RE: Comment Response Letter – Site Development Plan – Discount Tire - Falcon (File #: PPR2112)

COMMENT RESPONSE LETTER

Site Development Plan

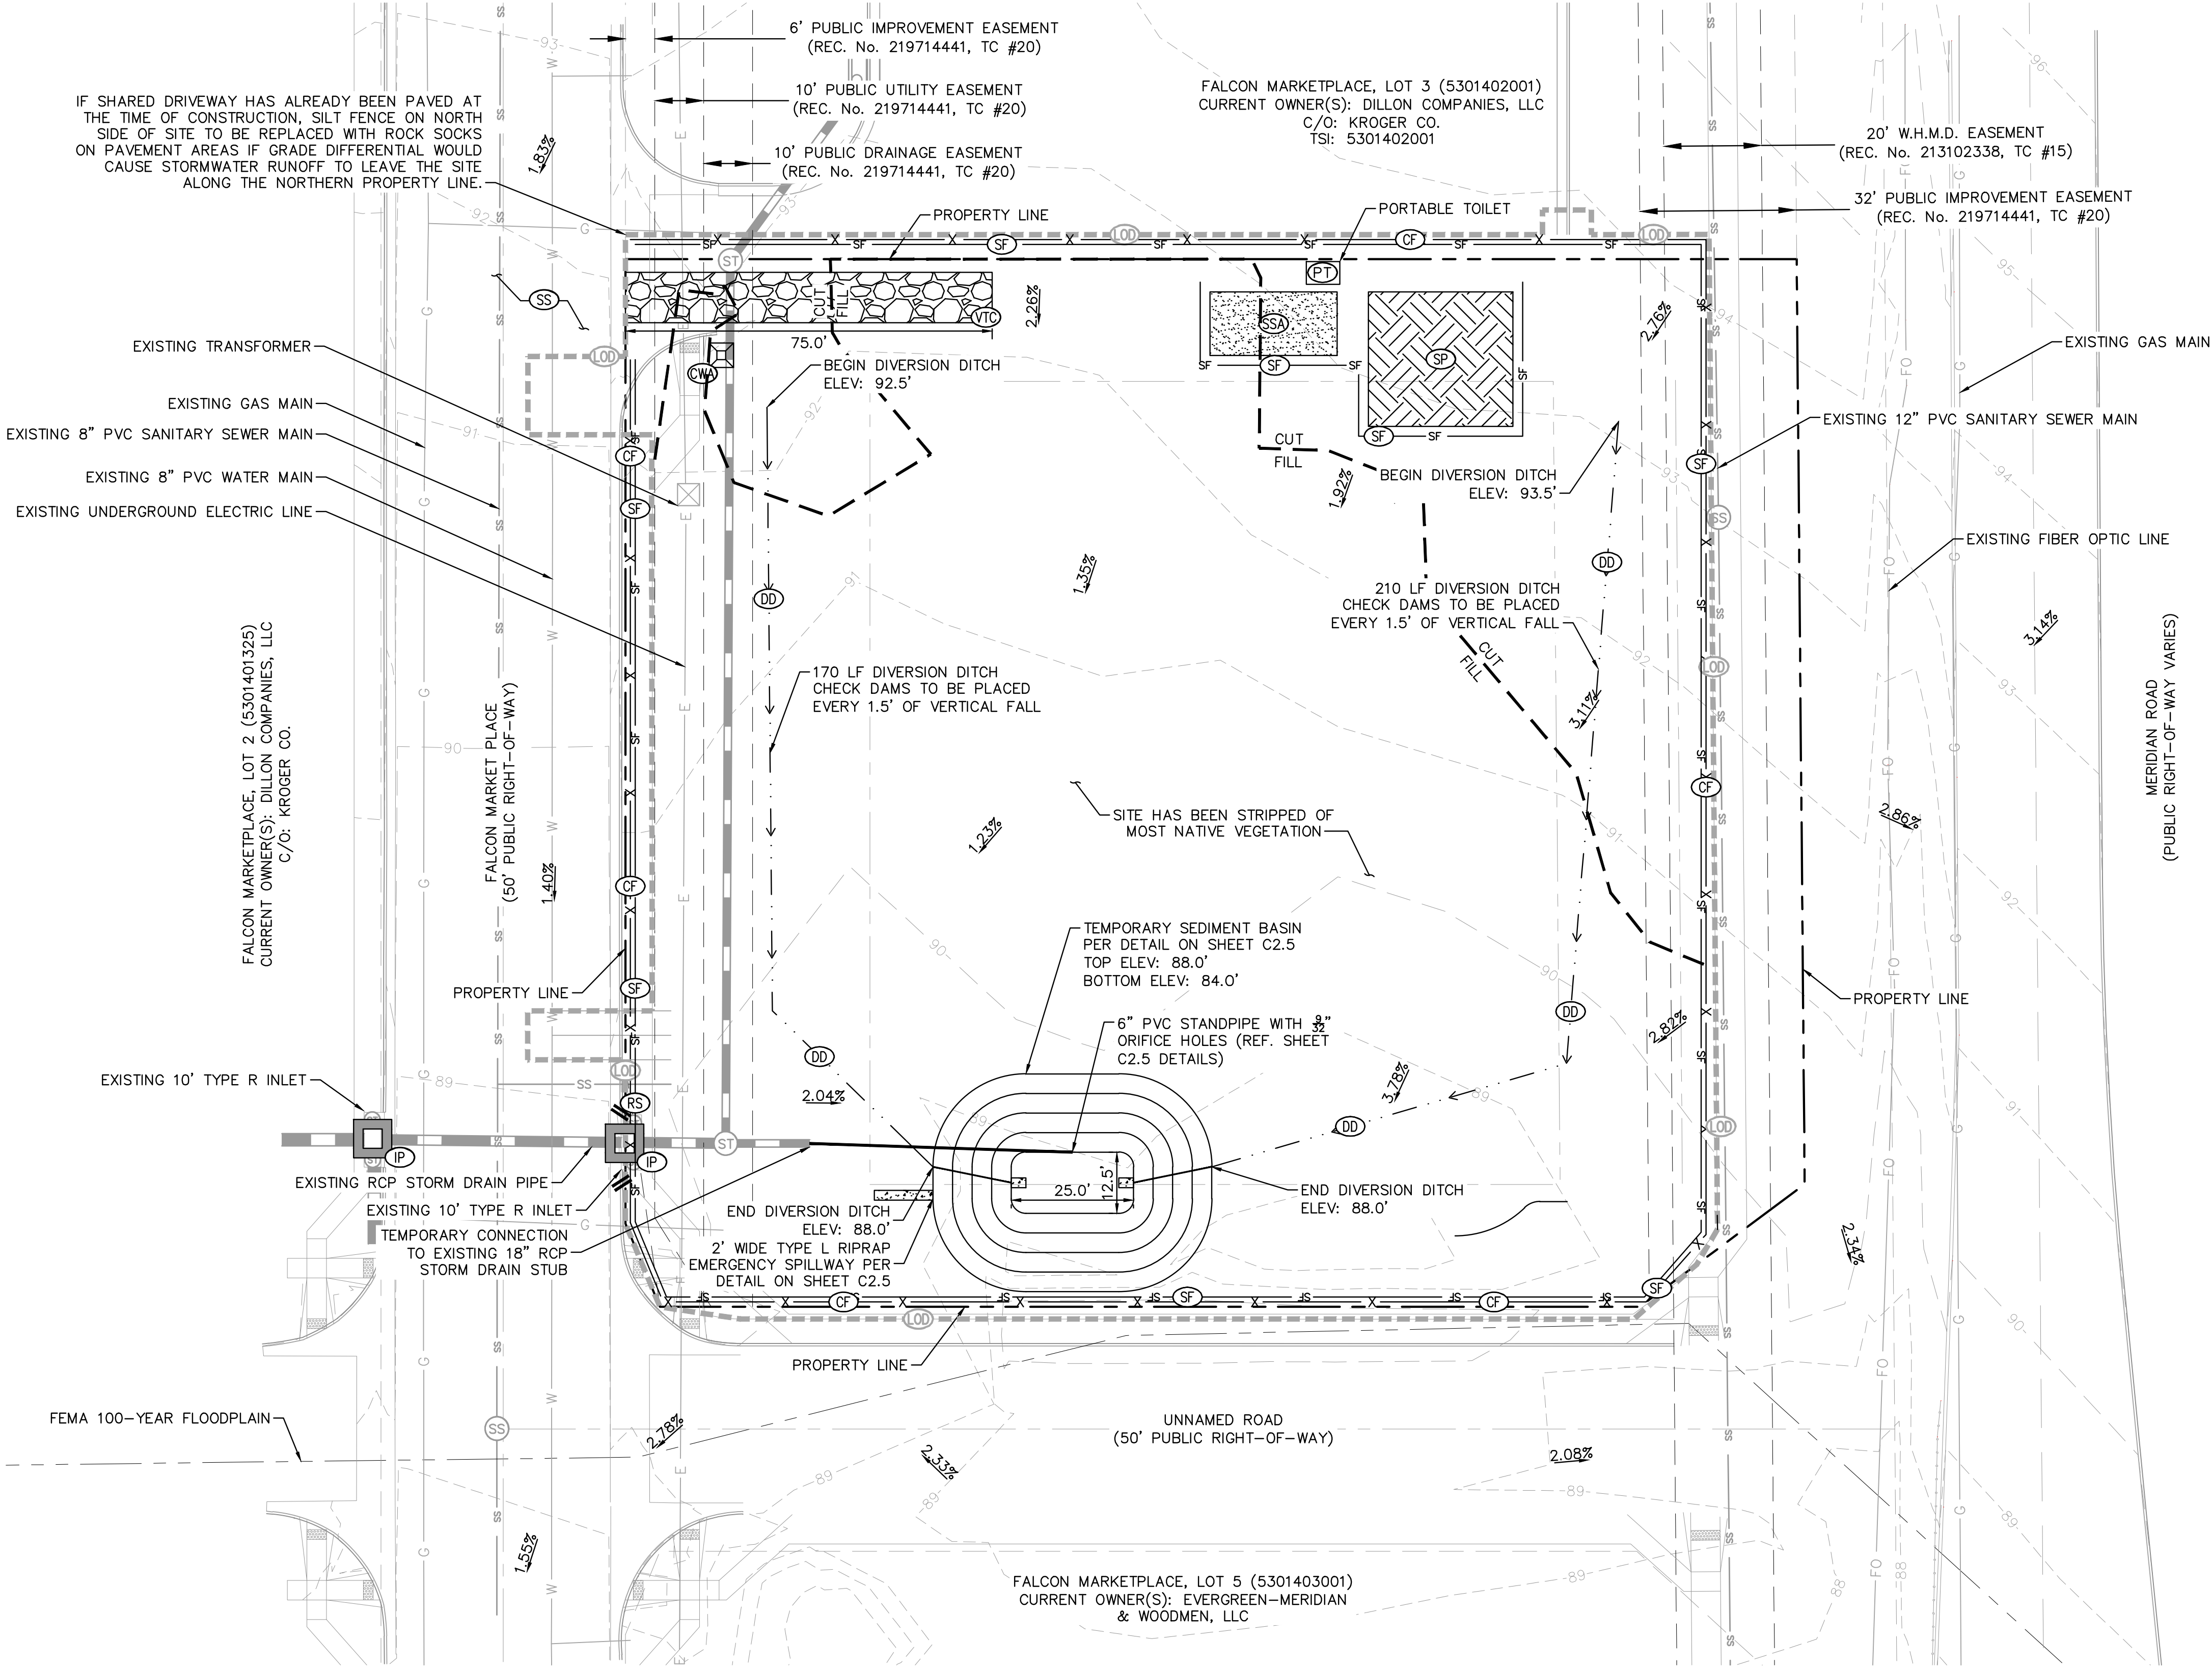
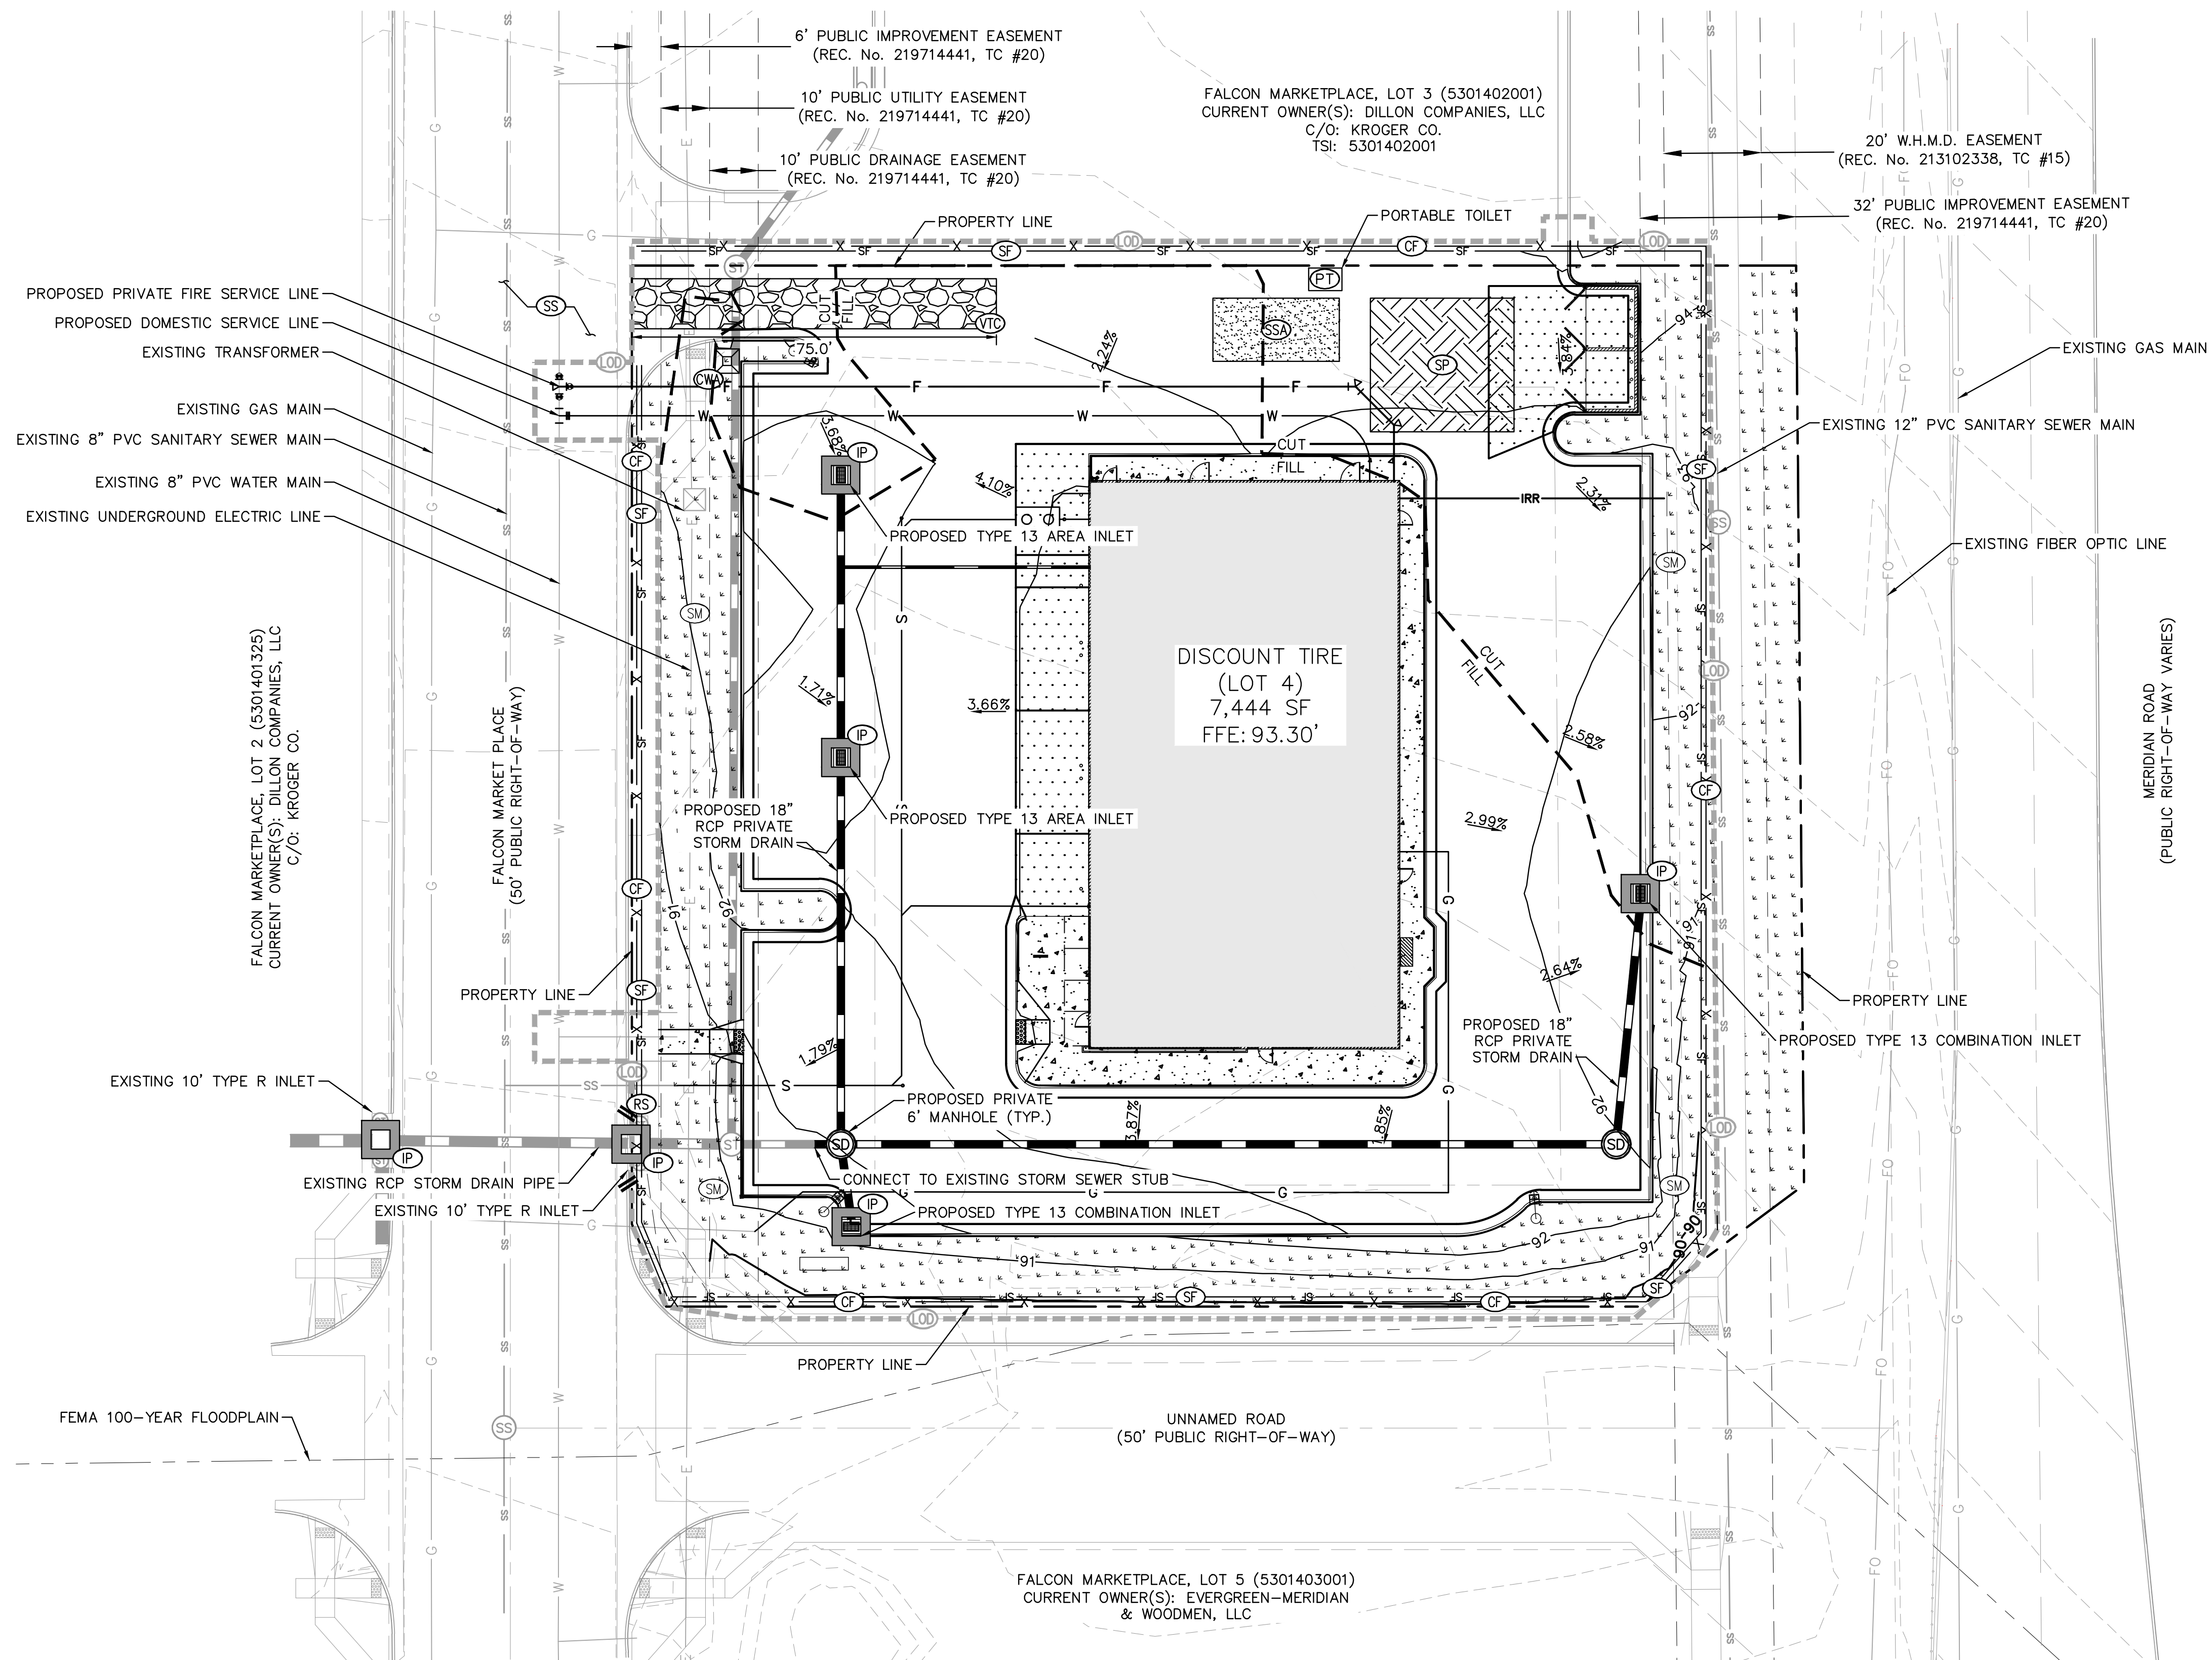
3. Change limits of construction to “Construction boundary/limits of disturbance” or add ‘limits of disturbance to the legend and figure.

4. Please show a few existing grade slopes labels offsite so it is clear where run-on is occurring

5. Show minimum length of VTC at 75', per detail

6. Add “DD” to legend and the subsequent line-type

7. Revise to show temporary slope drain pipe and riprap pad at the toe of the slope

8. Revise spillway per what is shown on detail (ie: the 2ft spillway riprap begins at the crest of the spillway, closer to the top of the embankment)

Would be helpful to also include a note here that explains where the spillway water will be conveyed to. Is there to be an inlet on this Unnamed Road, for example? Consider showing spillway routed west towards inlets so spillway water has somewhere to go.

- *Response: The legend has been updated as prescribed above.*

- *Response: Existing slope labels have been added offsite. The grading along the northern property line has been coordinated with the developer such that flows from both sites will remain on site. Existing over-lot grading contours are shown to adequately represent current site conditions.*

- *Response: VTC has is now shown and labeled as 75' in length.*

- *Response: The diversion ditch symbol and line-type have been added to the legend.*

- *Response: The riprap pad and temporary slope drain have been added to the sediment basin.*

- *Response: The spillway is now shown on the west side of the temporary sediment basin, directing flows west toward the existing inlet in Falcon Market Pl. A note has also been added to the sheet indicating destination of the emergency spillway flows.*
